Project Name : Land West of B2132 Bilsham Road

Job No. : 14-111

Note Title : Response to WSCC Highways Comments

Date : February 2018

Scale 1:500 @A1	Date DEC 17	Designed SD
Drawn SD	Checked MS	Approved R.JH
Job No 14-111	Drawing No 14-111/202	Rev

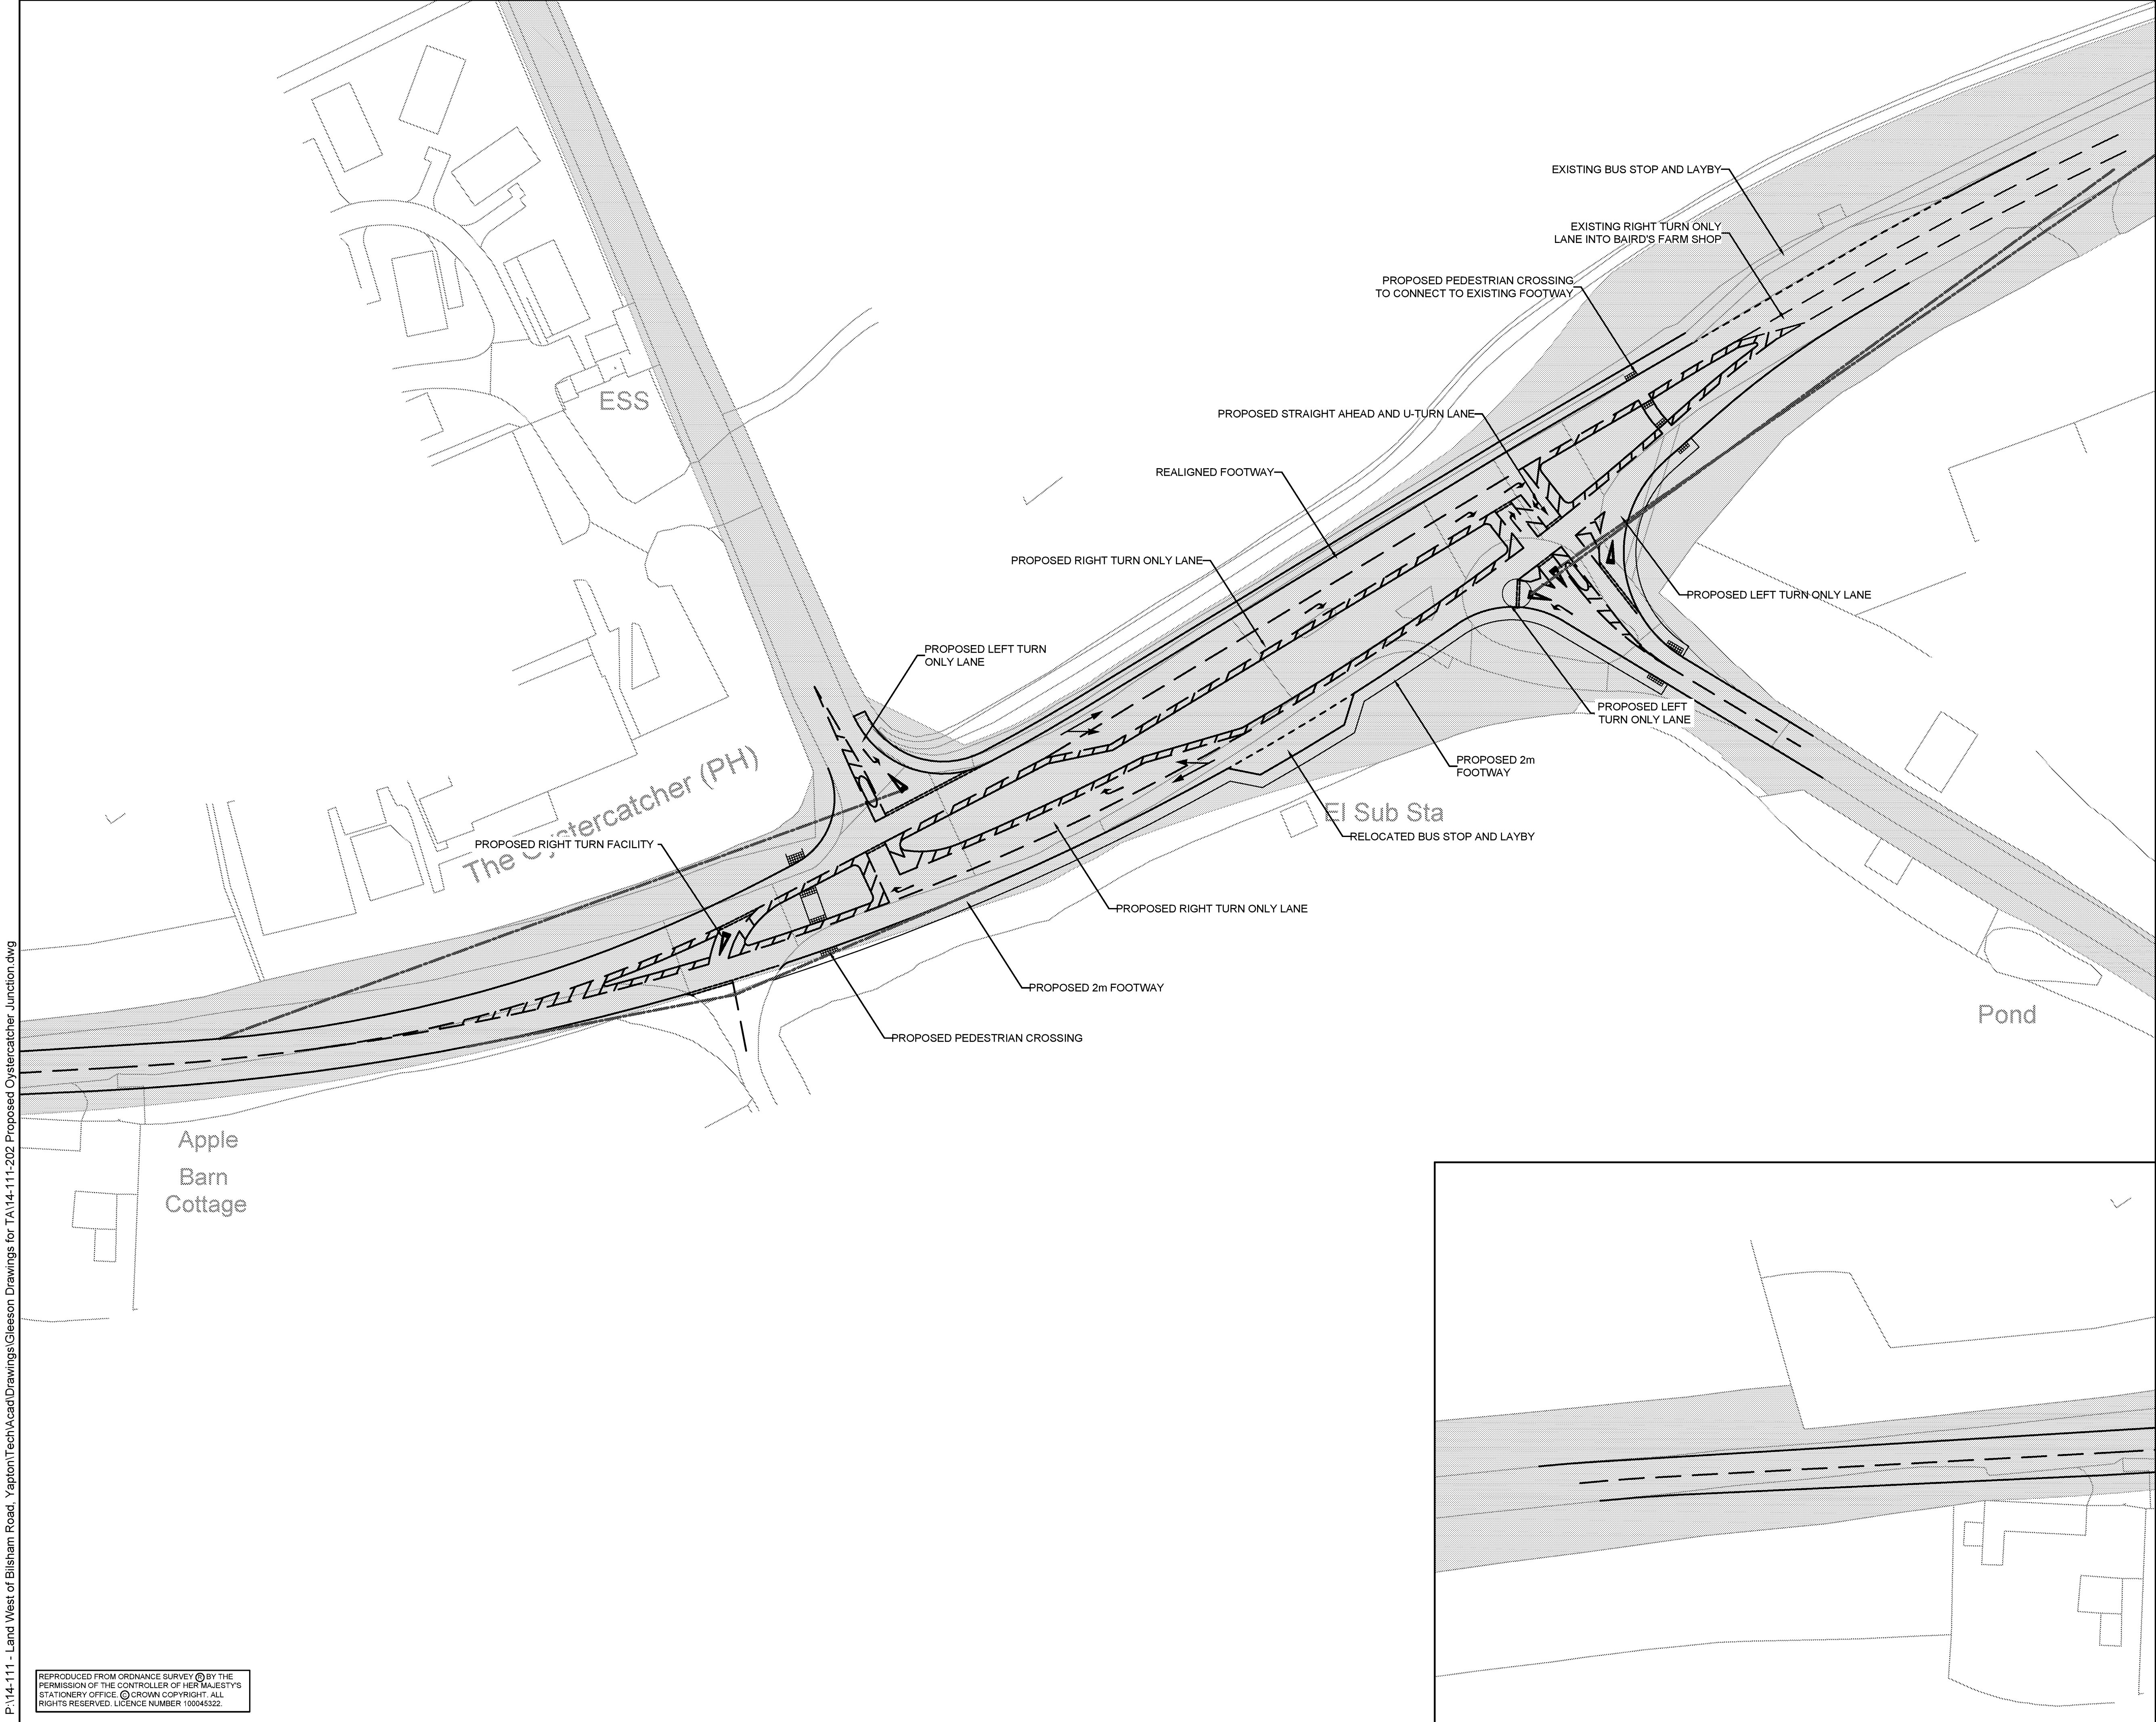
3.17 **Tables 3.7 and 3.8** show the sensitivity test results for the proposed junction improvements at the Comet Corner and Oystercatcher junctions on the A259.

3.18 As can be seen the proposed junction improvements enable the additional developments to be catered for due to the step-change in capacity that they will deliver.

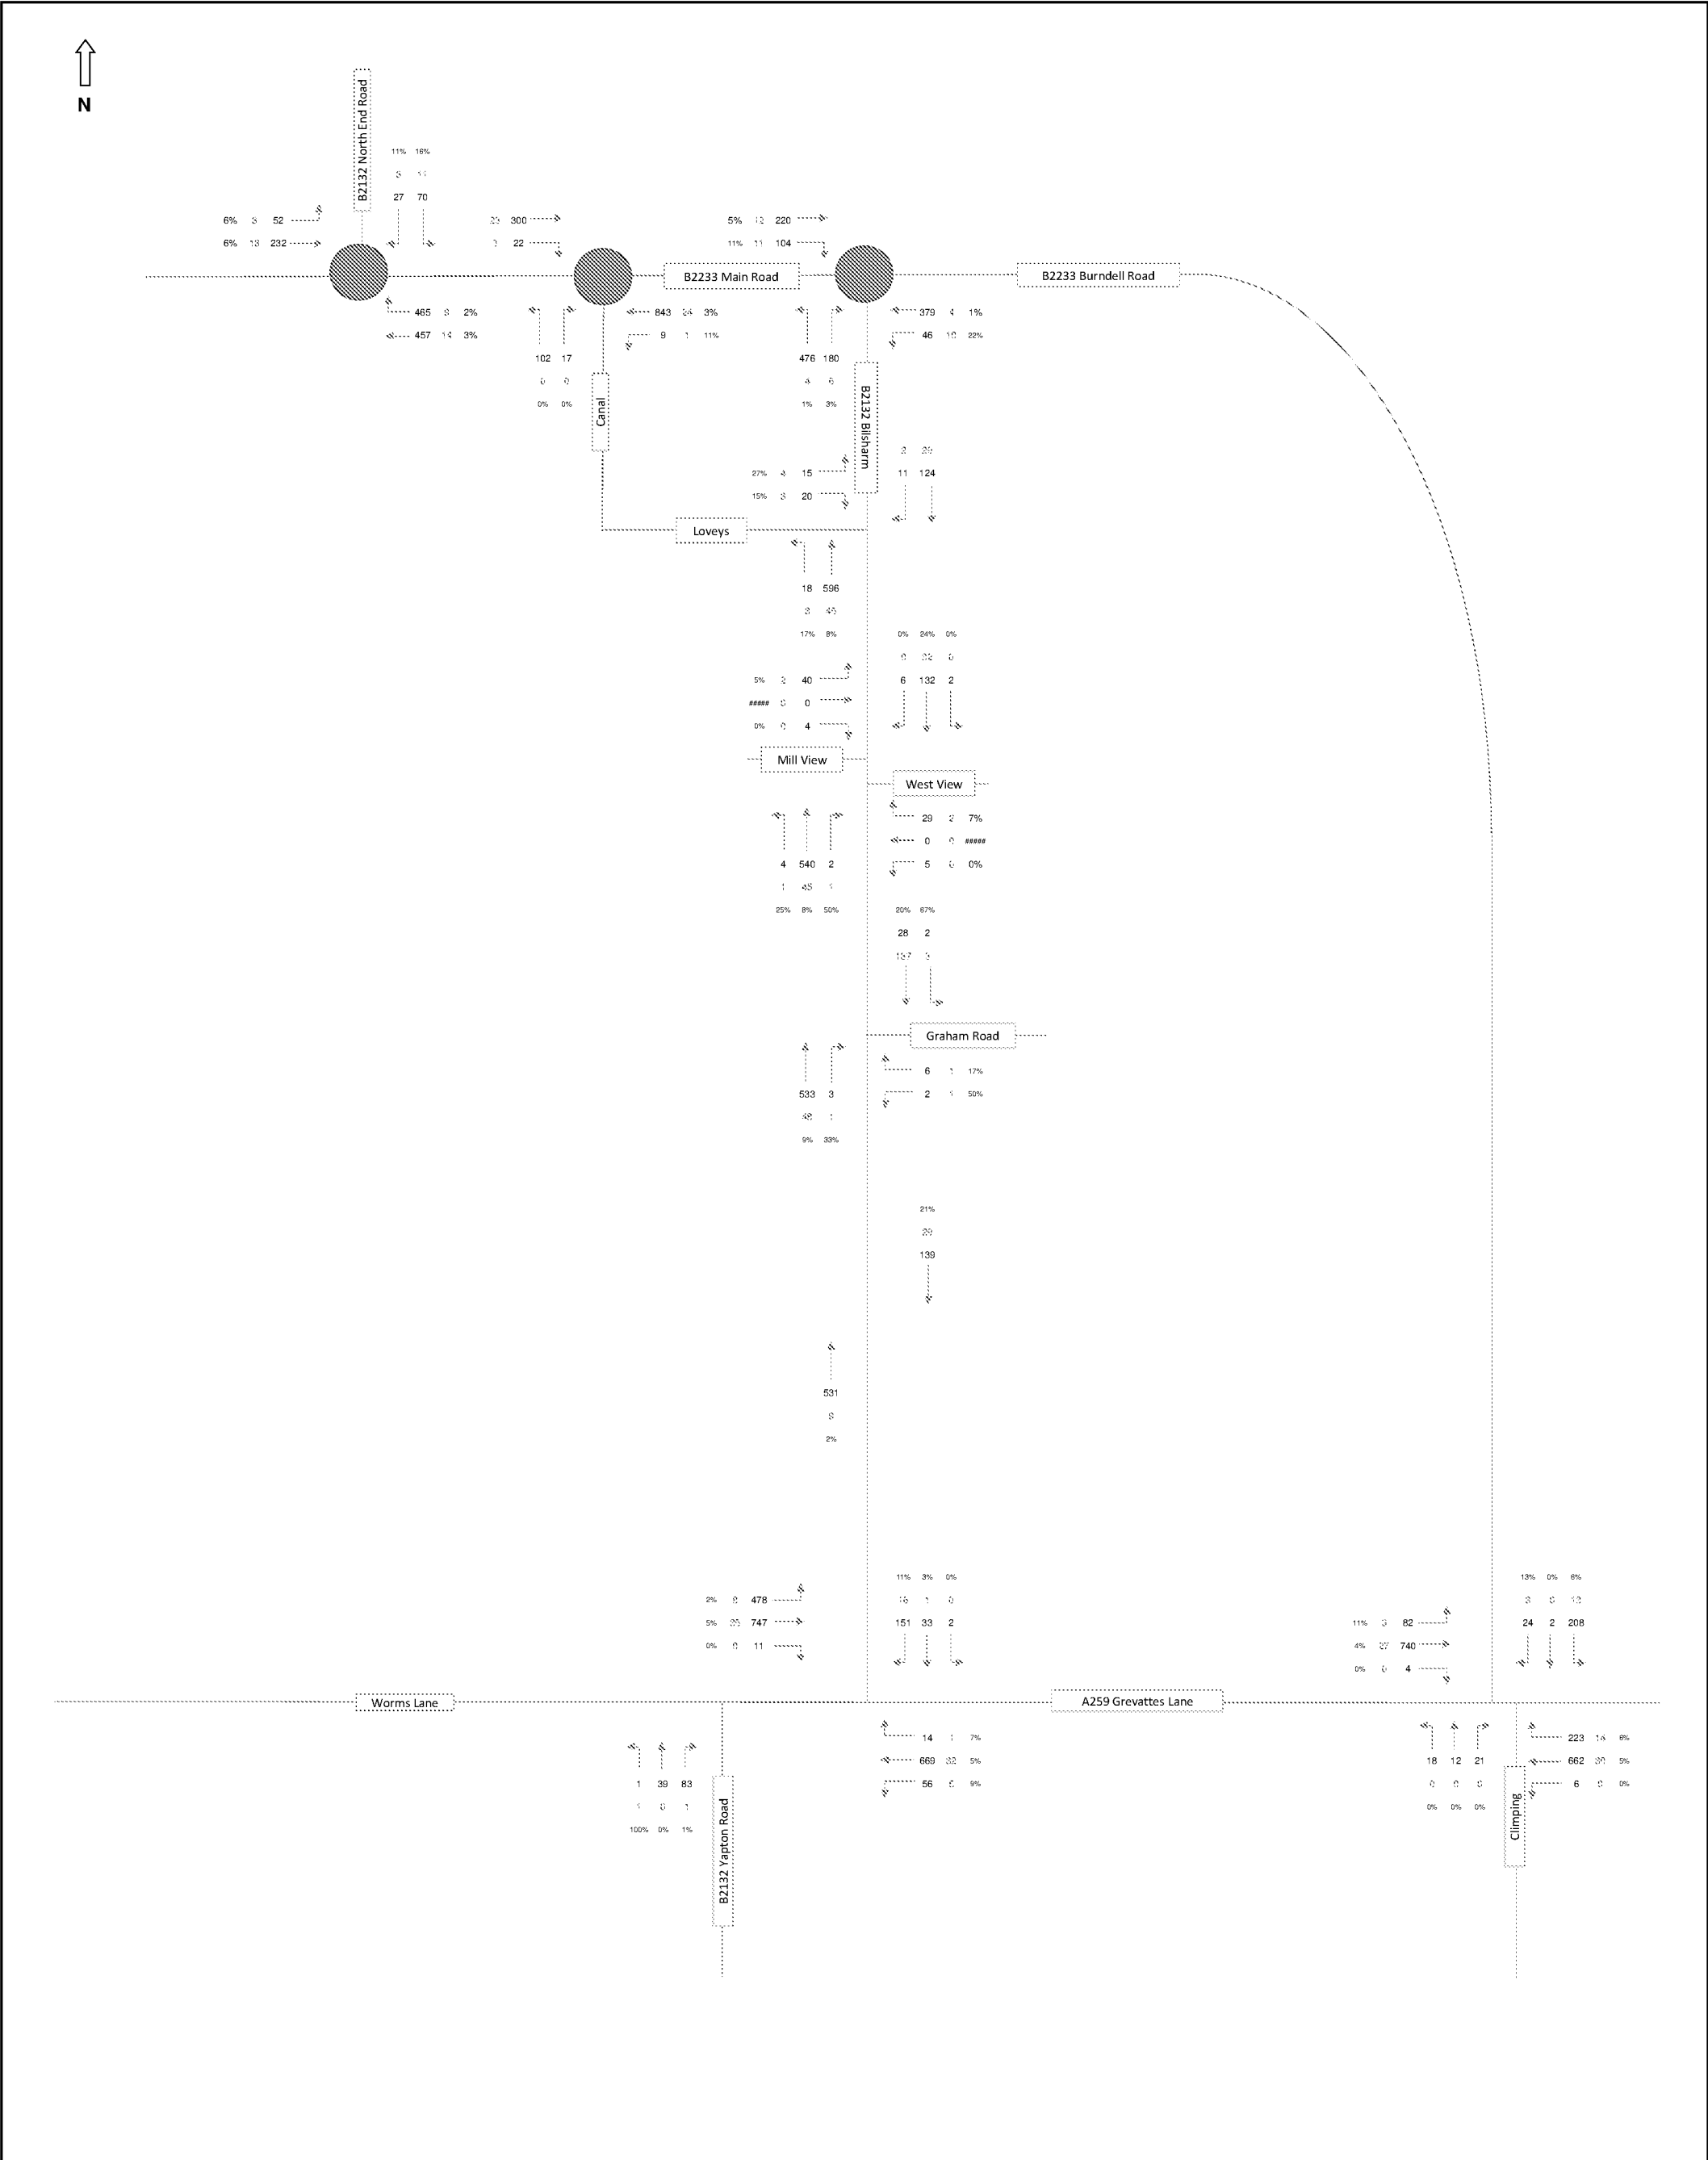
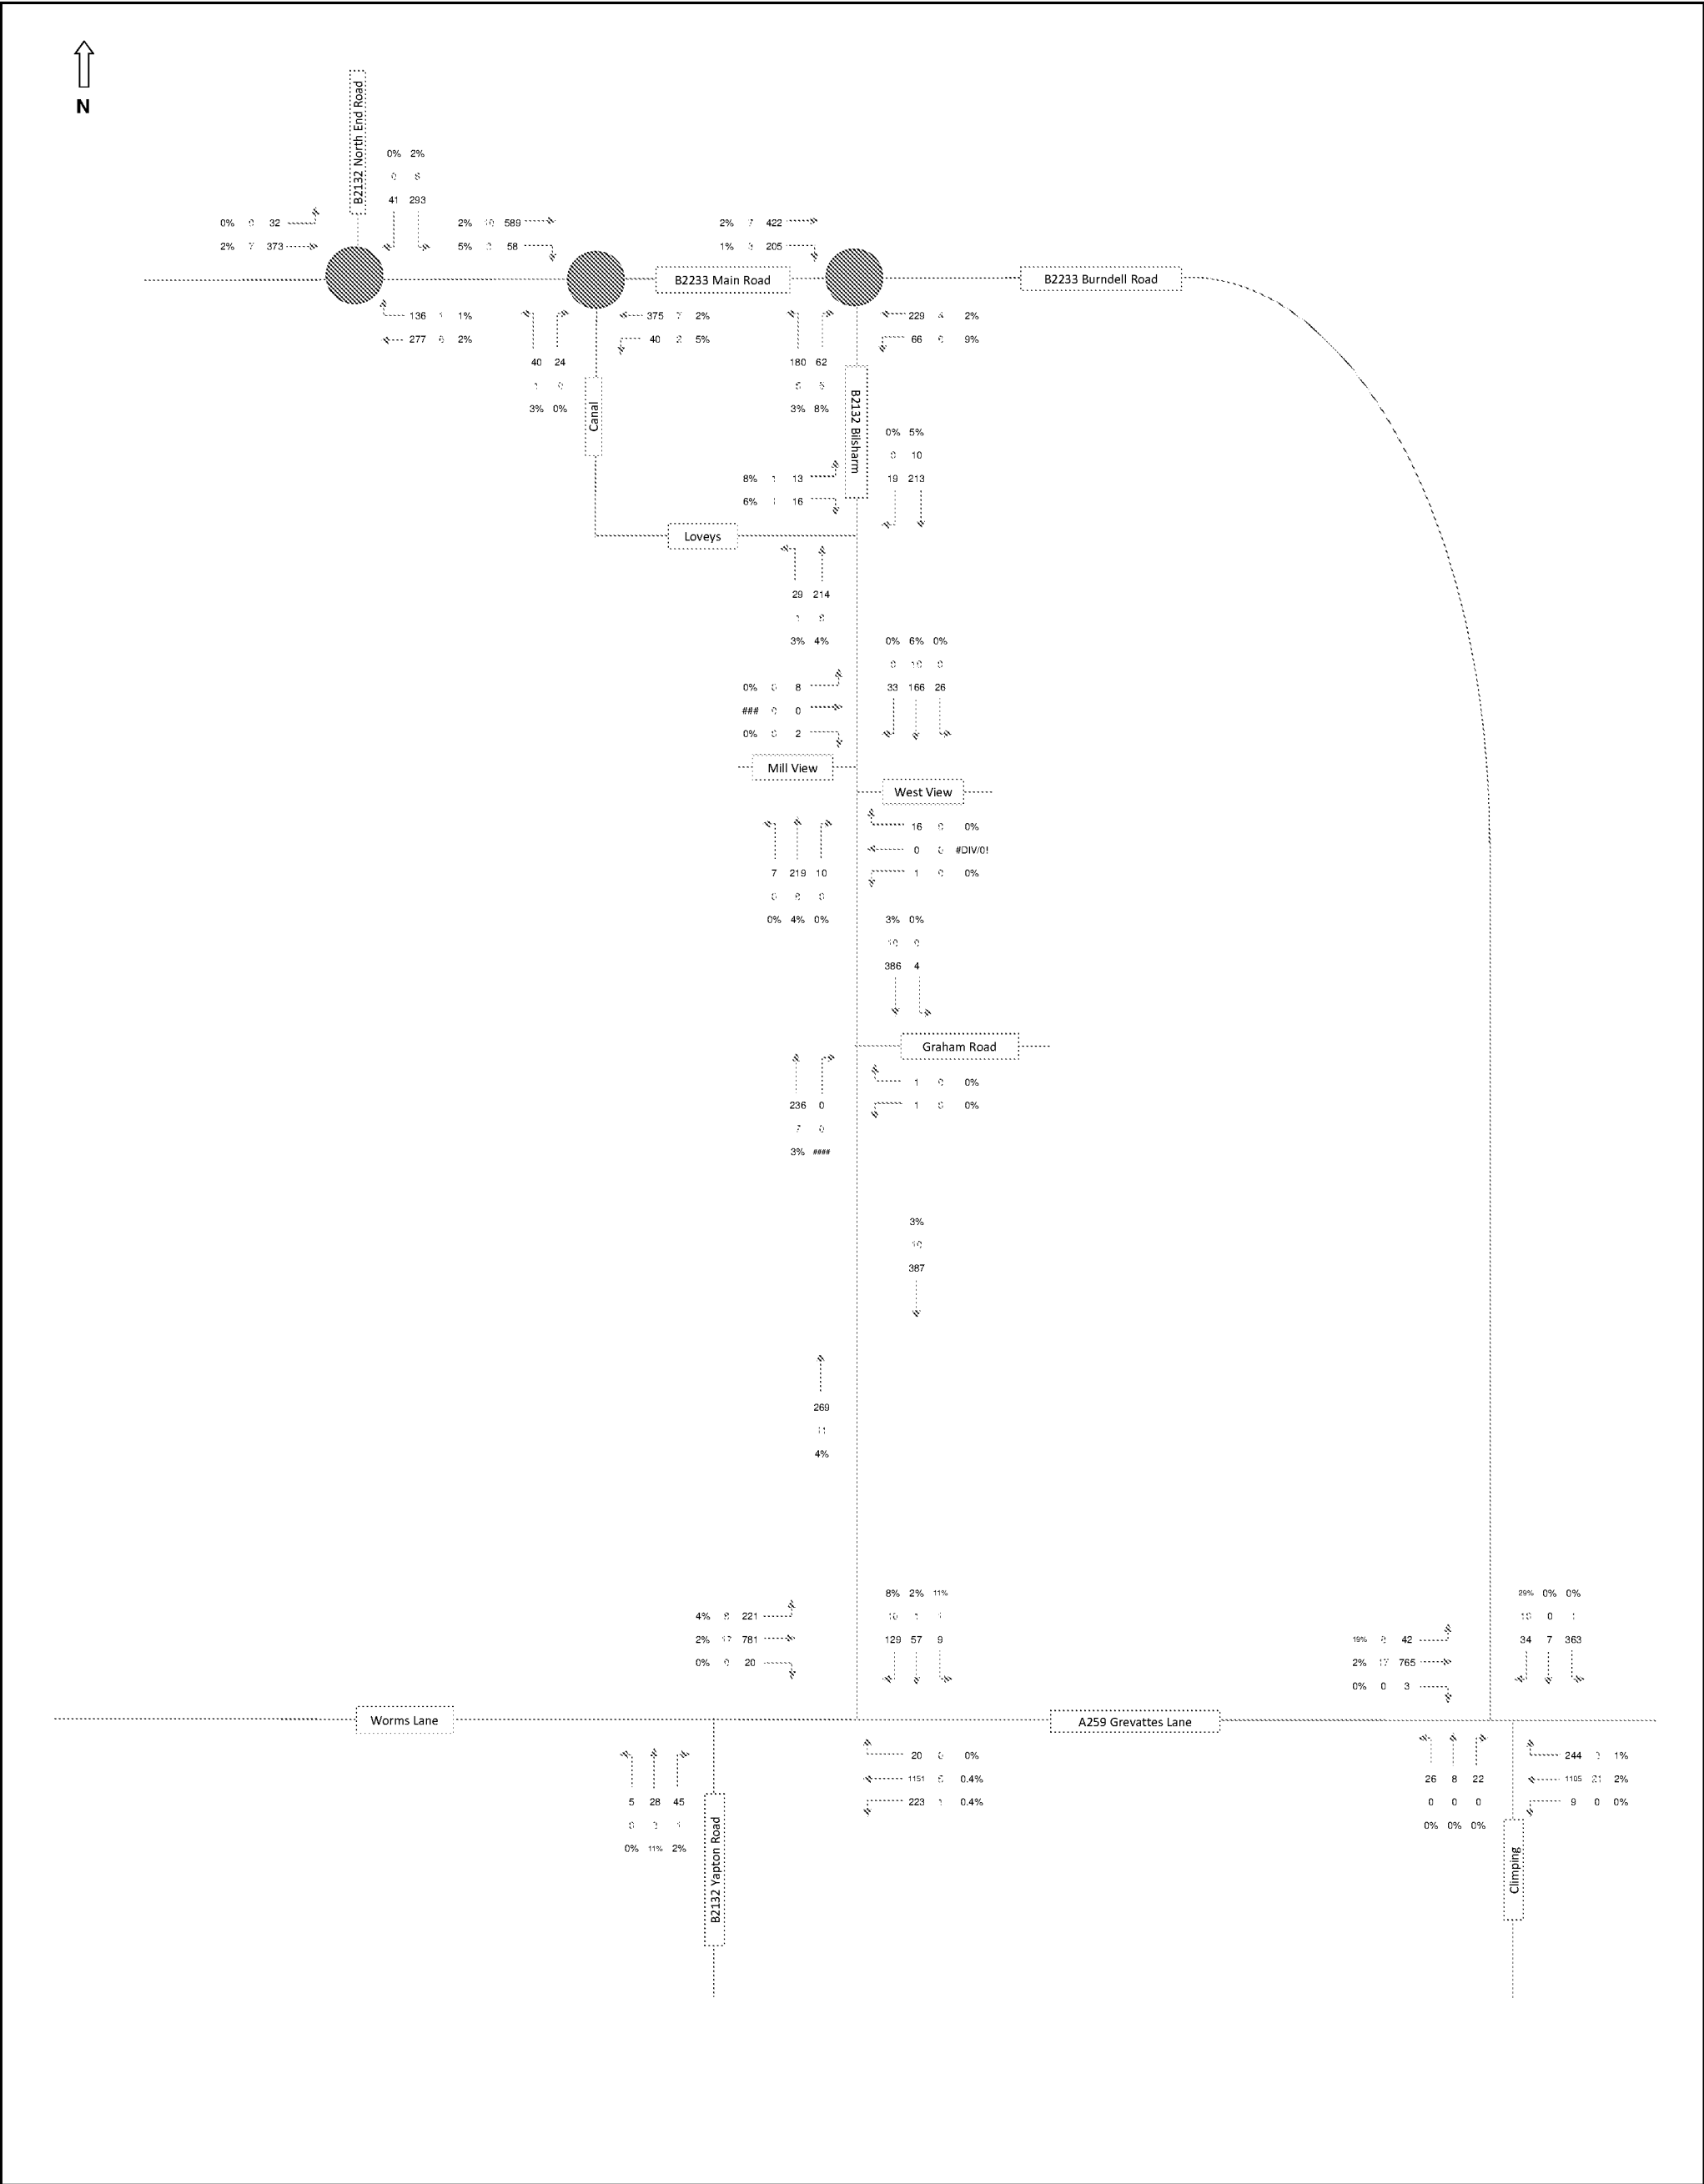
- 2.6 WSCC have also requested additional information relating to the distribution and assignment of development traffic on the local highway network.

“Within the pre-application discussions it was requested that information would be required to confirm the assumption utilised in the production of the gravity model and the subsequent distribution. This has not been provided.”

- 2.11 For clarity additional traffic flow diagrams have been included in **Appendix C** of this TN. These show the percentage and number of development traffic vehicles assigned and distributed to the local highway network.
